**City of Albuquerque Department of Municipal Development
Comments for DRB Hearing on 7/31/19**

Project # PR-2019-002574

Transportation and Drainage Section:

**SITE PLAN**

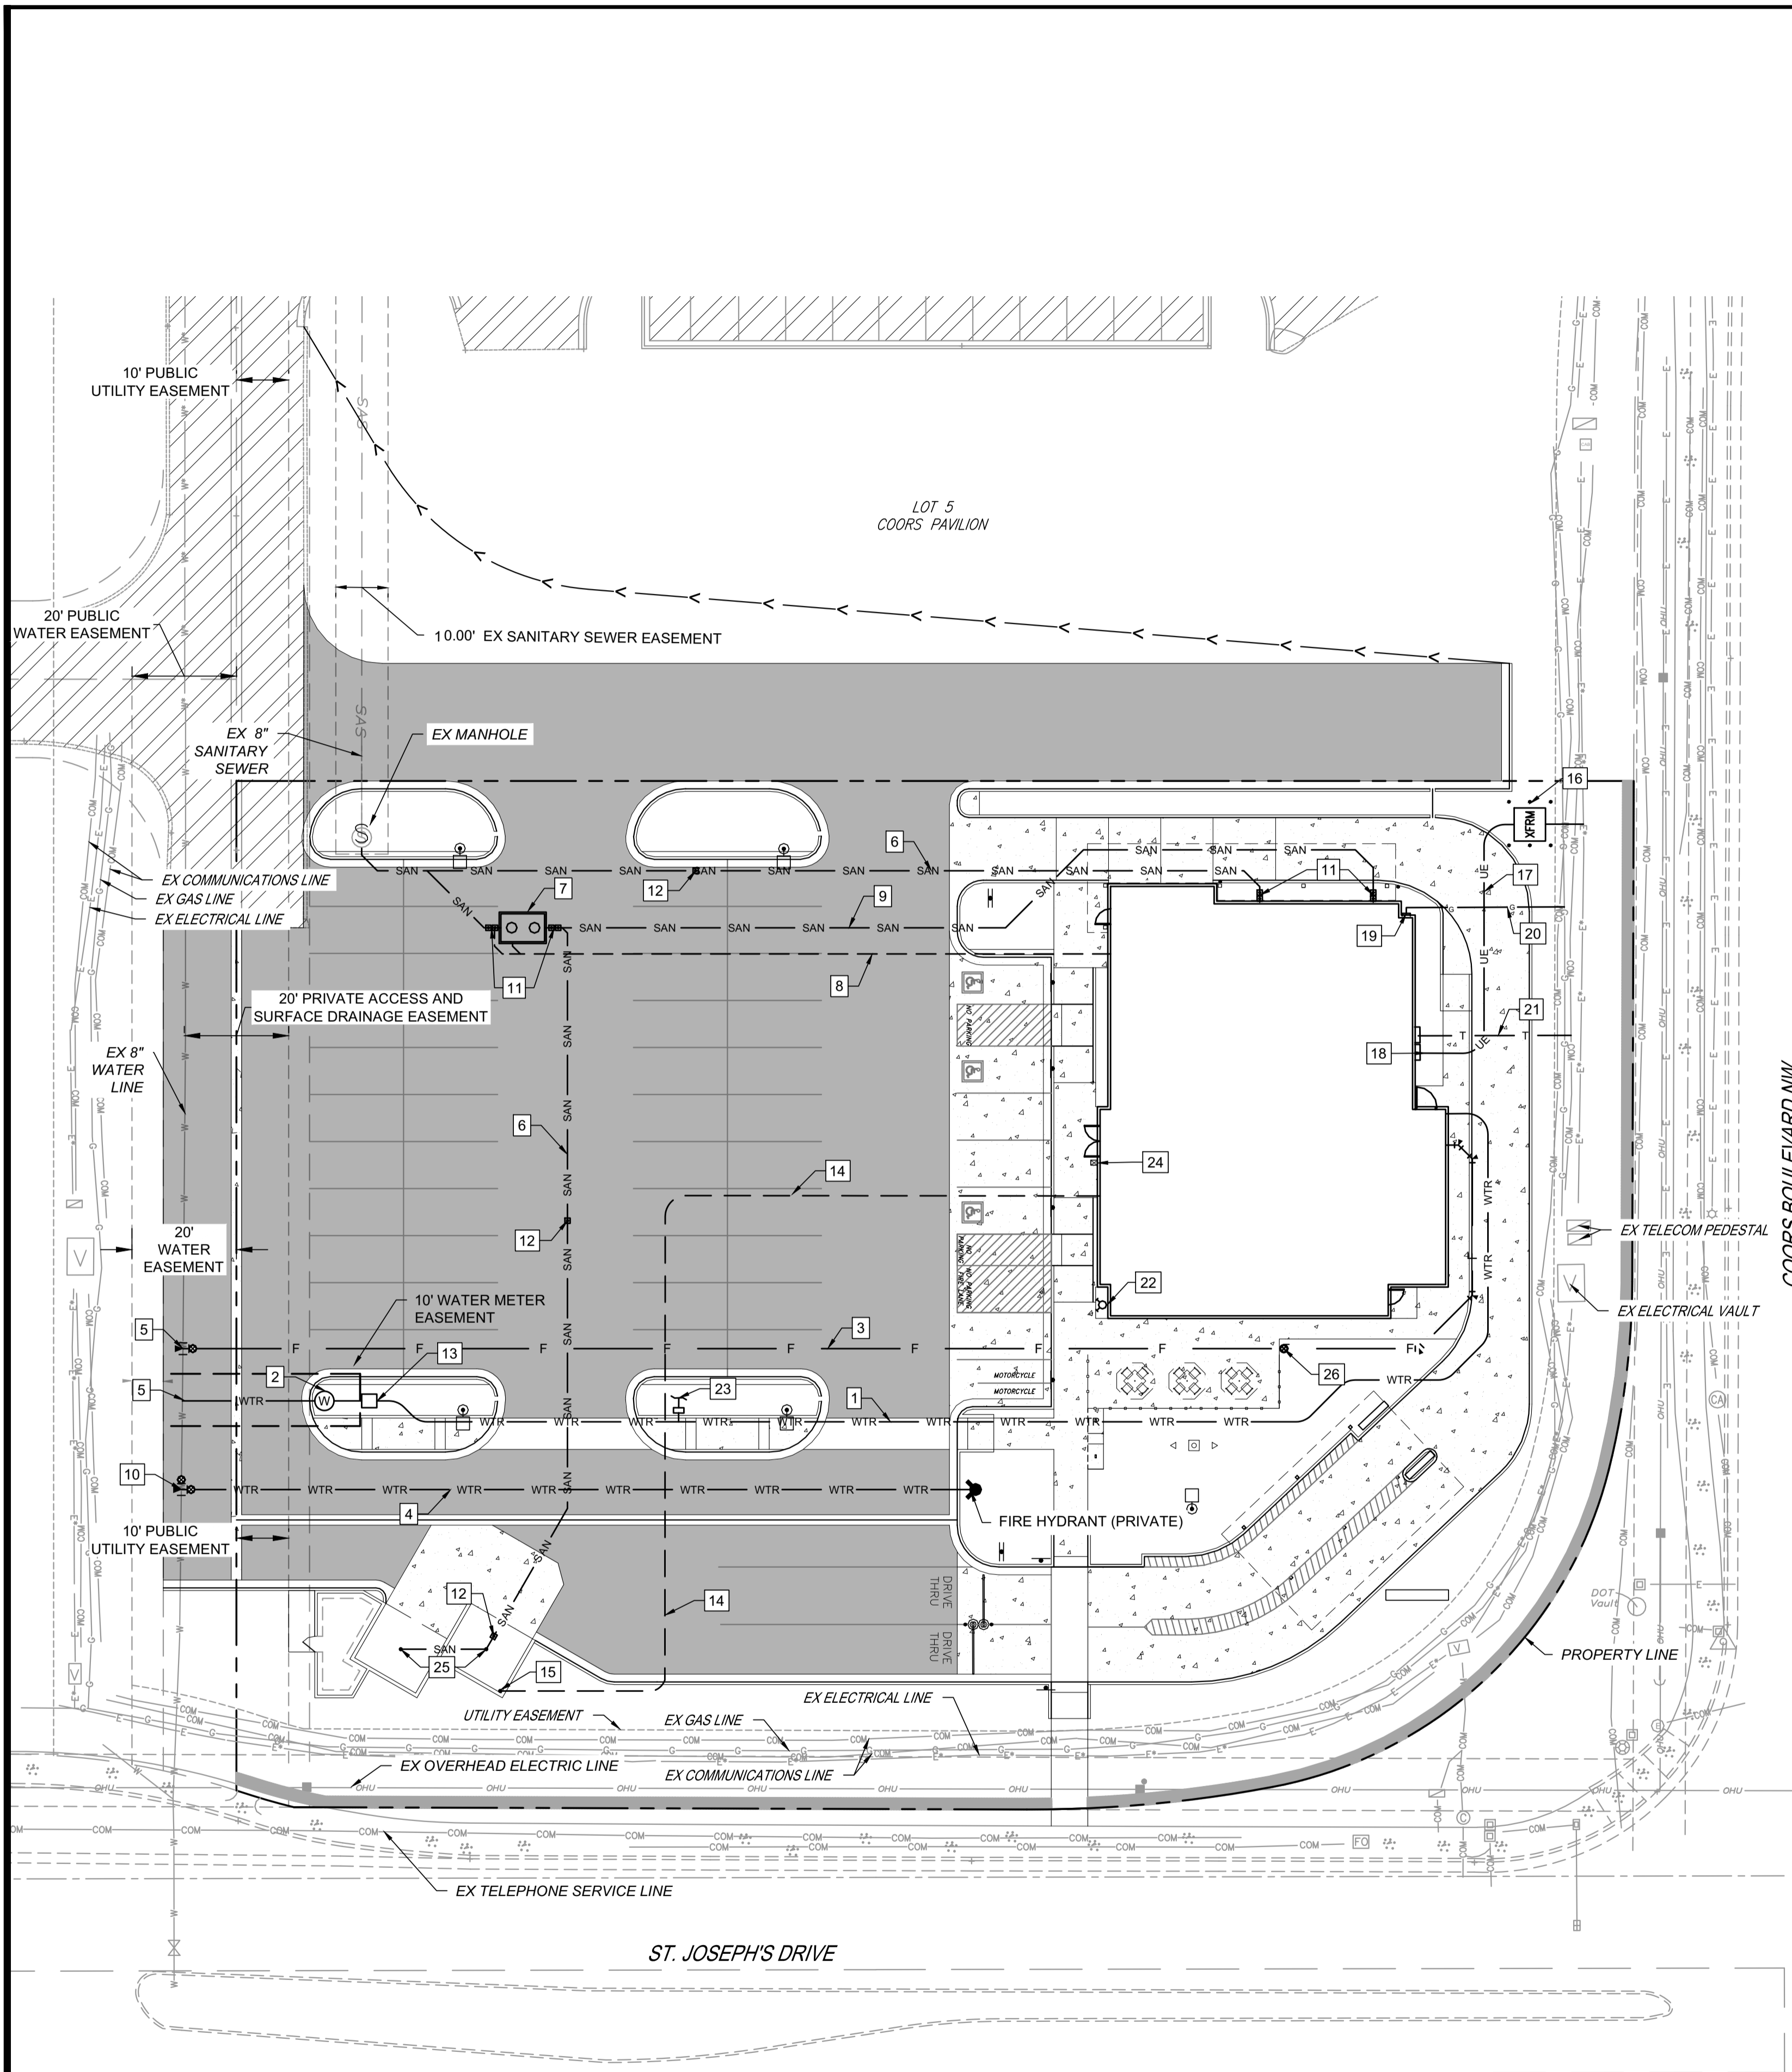
Per the 2040 Long Range Bicycle Map, a bike lane is proposed on St. Joseph's Dr.

Response: A 6ft Roadway, and 6ft Utility Easements are being generated to comply with the request from Engineering.
